From: Juan Baeza
Sent: 11 September 2018 15:24
To: Planning.Responses
Subject: FW: FG/33/18/PL

From: [REDACTED]
Sent: 11 September 2018 15:21
To: Juan Baeza
Subject: FW: FG/33/18/PL

No highway objection.

TITLE PROPOSED SITE & BLOCK PLAN	DWG NO 5285-2	REV C
--	-------------------------	-----------------

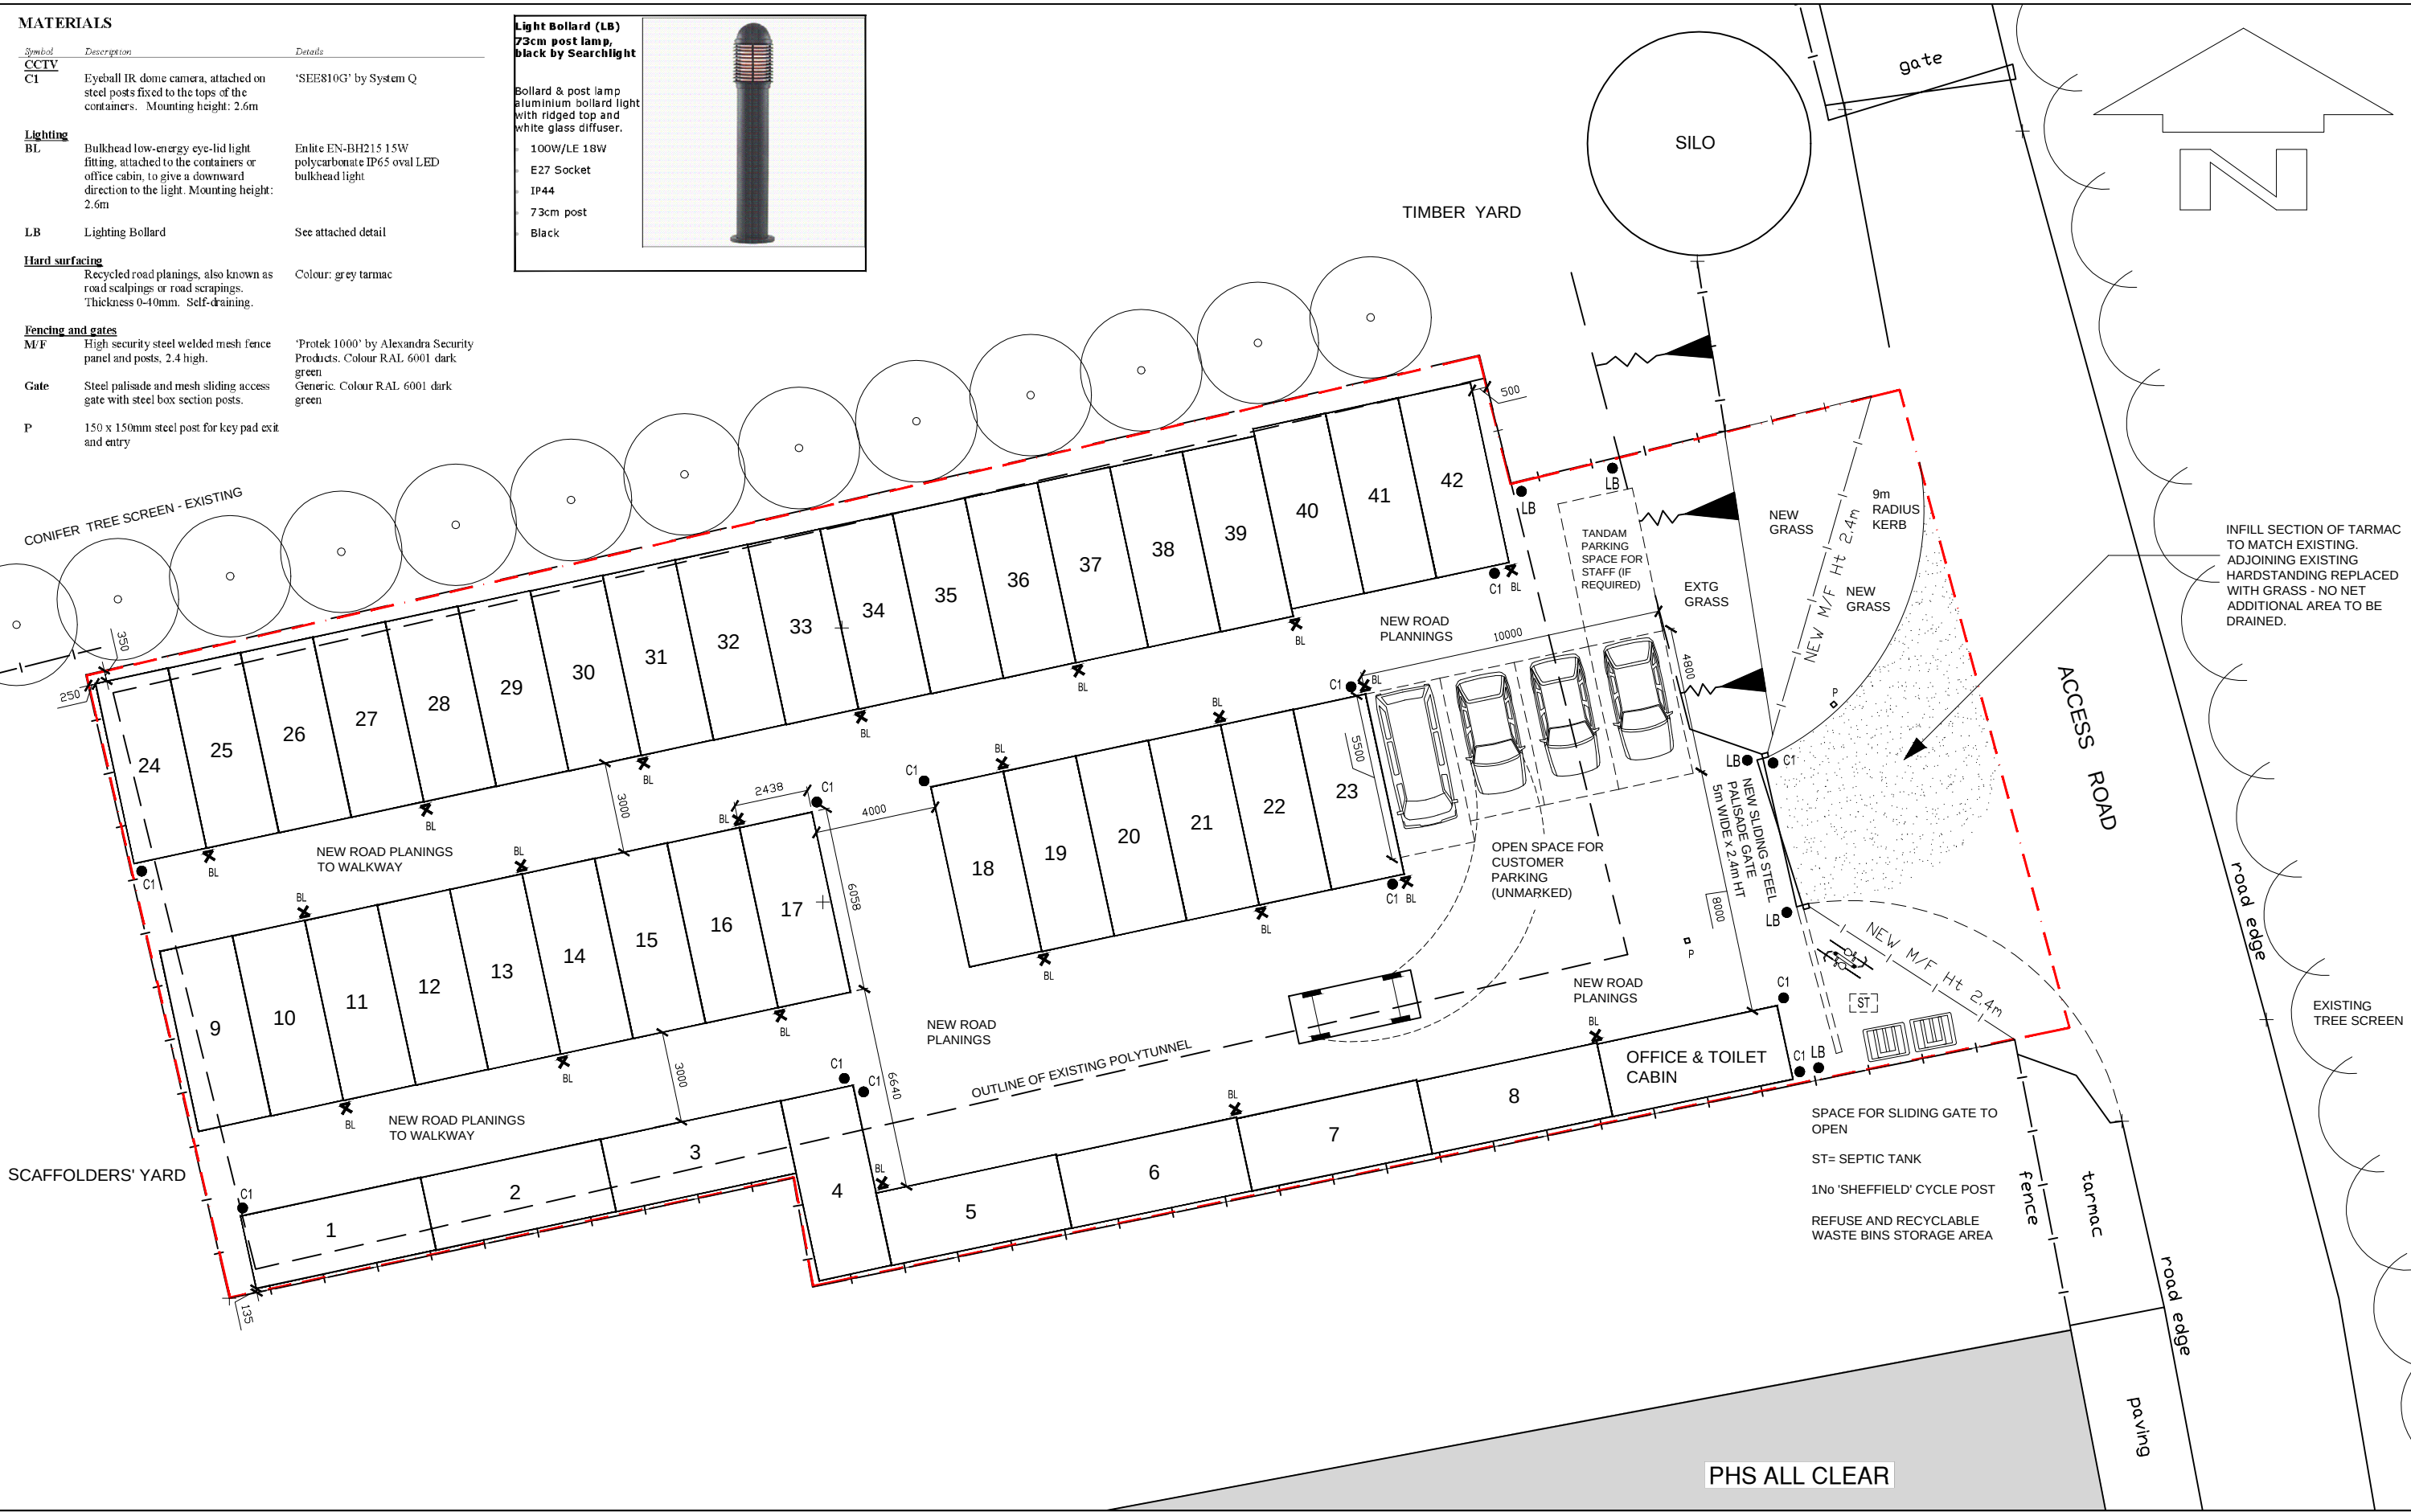
The access into the site is from a private lane – this access is to be altered to ensure a large vehicle enter and leave the application site in a forward gear.
